**From:** Martin Hill <[Martin.Hill@arun.gov.uk](mailto:Martin.Hill@arun.gov.uk)>  
**Sent:** 18 November 2020 20:20  
**To:** Planning.Responses <[Planning.Responses@arun.gov.uk](mailto:Planning.Responses@arun.gov.uk)>  
**Subject:** RE: Planning Consultation on: FP/209/20/PL

Comments from Private Sector Housing:

**Application No:** FP/209/20/PL  
**Registered:** 27th October 2020  
**Site Address:** The Old Barn 42 Felpham Road Felpham PO22 7DF  
**Grid Reference:** 494894 99617  
**Description of Works:** Change of use of the ground floor public house (Sui Generis Use) to create 2 No. 2 bed dwellings (C3 Use Class), subdivision of the first floor 1 No. 5 bed flat to create 1 No. 2 bed flat & 1 no. 1 bed flat. This site is in CIL Zone 4 (Zero Rated) as flats.

Proposed FF Plan at 1:100 scale

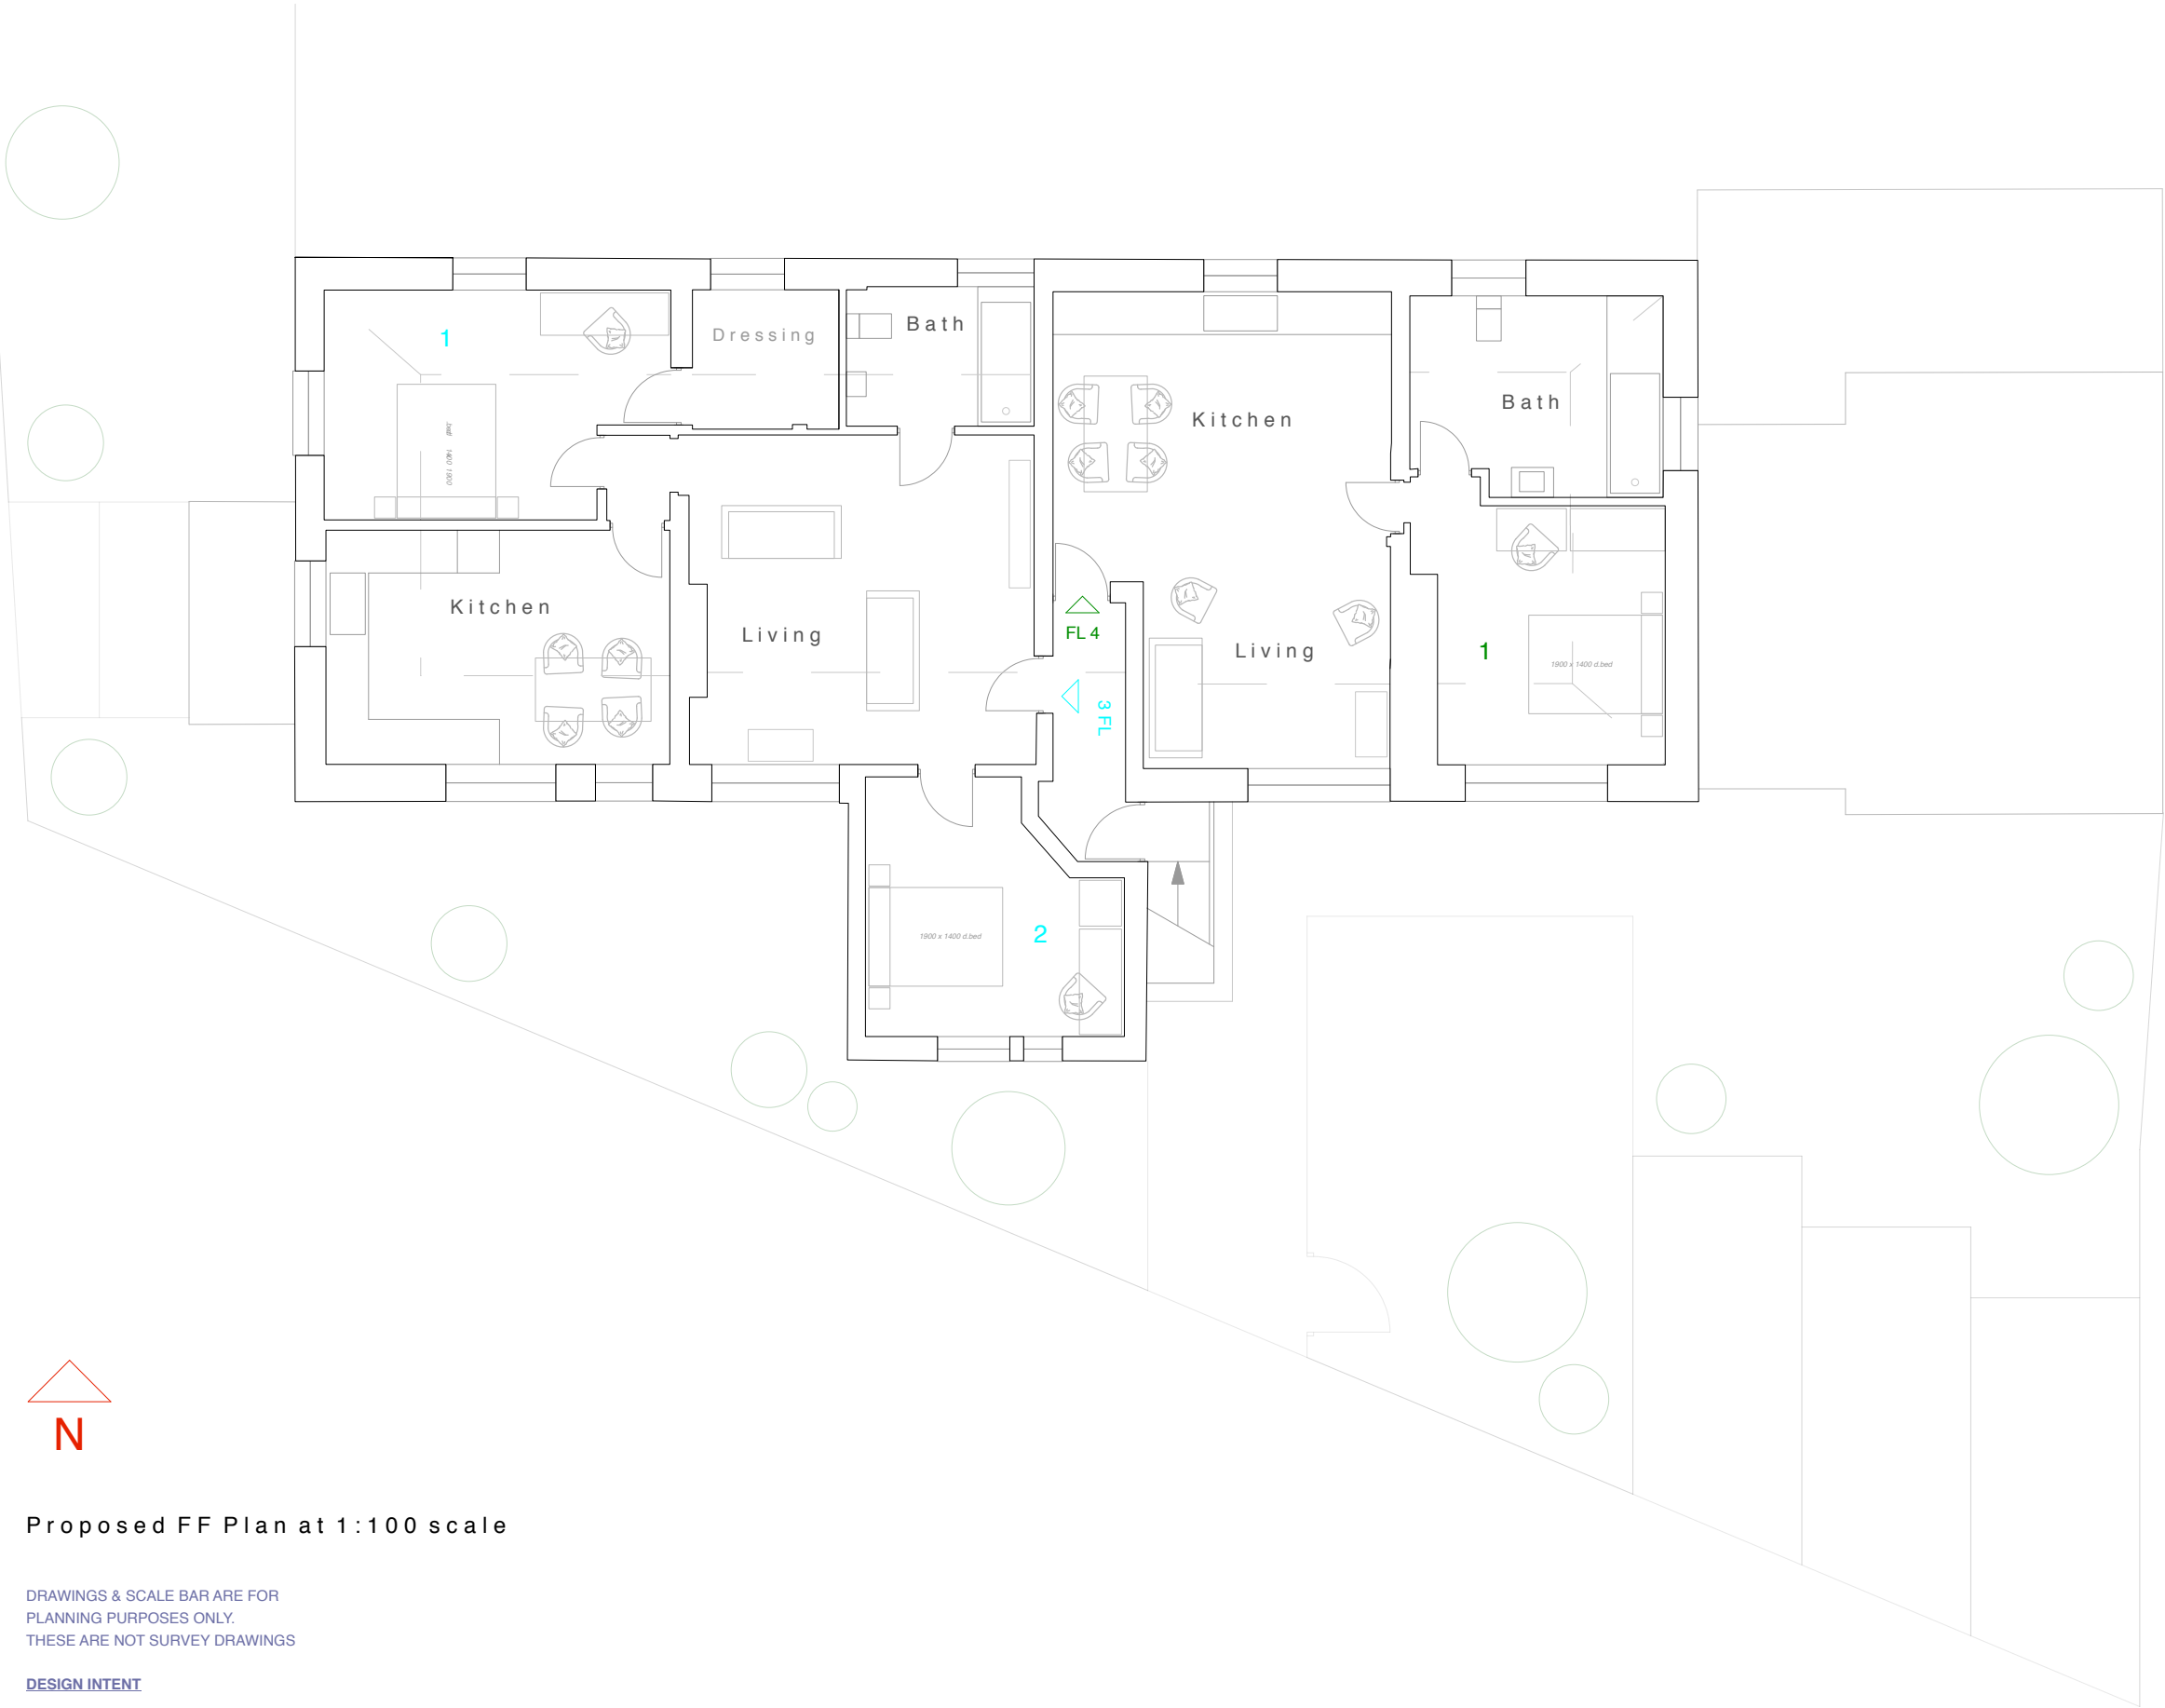
- Flat 3 on the first floor – The flat entrance door must meet the specification of FD30S and the compartment wall separating the flat and the escape route should be a minimum 30 minutes fire resisting. Bedrooms 1 & 2 are inner rooms and open into an unprotected area which is the living area. The compartment walls separating each bedroom from the living area must be a minimum 30 minute fire-resisting and fitted with an FD30S door. Additionally, a window meeting the specification for an escape window must be installed in both bedrooms to provide for an alternative means of escape in the event of a fire occurring in the living area.\*

- Flat 4 on the first floor – The flat entrance door must meet the specification of FD30S and the compartment wall separating the flat and the escape route should be a minimum 30 minutes fire resisting. The bedroom is an inner room and opens into an unprotected area which is the combined kitchen and living area. The compartment wall separating the bedroom from the kitchen and living area must be a minimum 30 minute fire-resisting along it's entire length (including the bathroom) and fitted with an FD30S door from the access room (kitchen and living area). Additionally, a window meeting the specification for an escape window must be installed in the bedroom to provide for an alternative means of escape in the event of a fire occurring in the kitchen and living area.\*

- Minimum 30 minute fire resisting escape route serving flats 3 & 4 on the first floor.
- There must be a minimum 30 minutes fire resistance between the ground and first floors.
- Upon a suitable and sufficient risk assessment being undertaken, consultation with national guidance and West Sussex Fire & Rescue Service, the appropriate level and coverage of fire alarm and detection system(s) to be installed should be identified, which must include interlinked smoke detection between entrance halls, access rooms and bedrooms in each flat. Subject to the level of horizontal compartmentation between the ground and first floors and compartmentation separating a shared hallway (flats 3 & 4) additional interlinked fire alarm and detection system(s) may be needed.
